**Re: Objection to MP08\_0244 MOD 1 Modification Request for Mixed Used Development at 23-37 Lindfield Avenue and 11 Havilah Lane, Lindfield**

1 SHADOW DIAGRAM - 21stDEC_9AM
5003 SCALE1 : 650

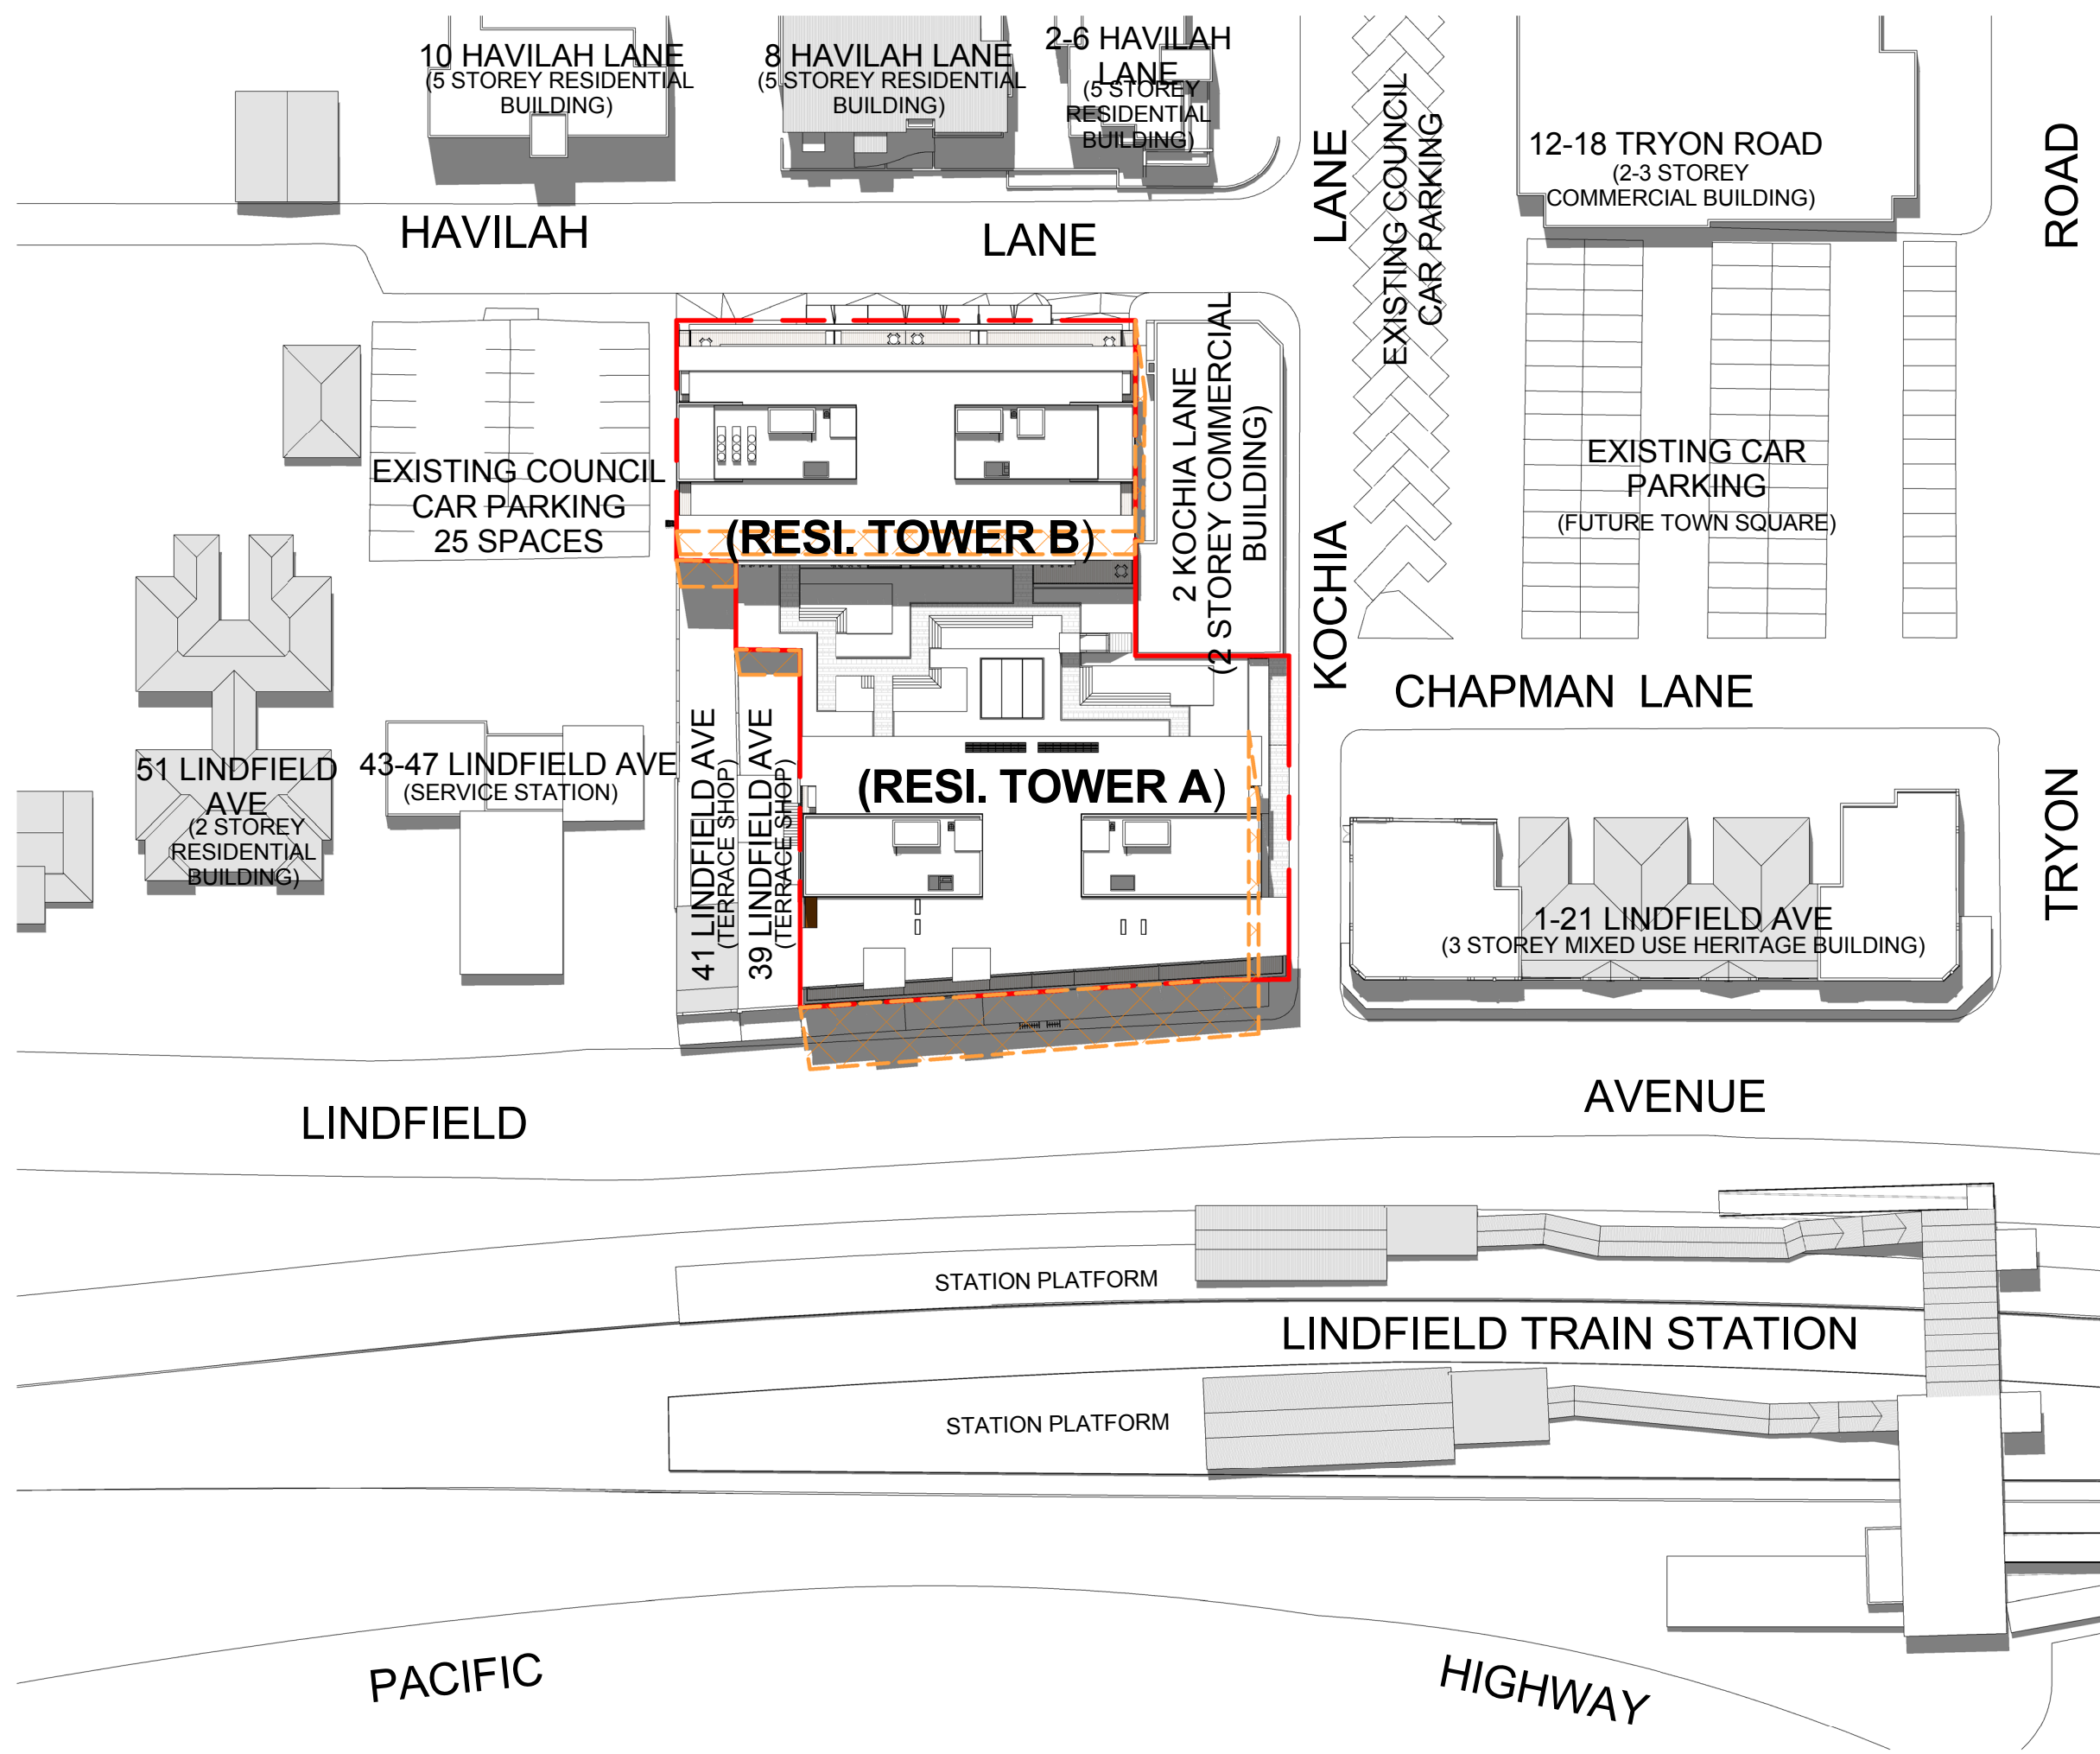
- The additional storeys create additional shadowing: particularly after 3pm for residents in the Havilah Lane apartments, and for all commuters on the city bound Lindfield rail platform, instead of 50% of the year, it will now be 75% of the year in the mornings.
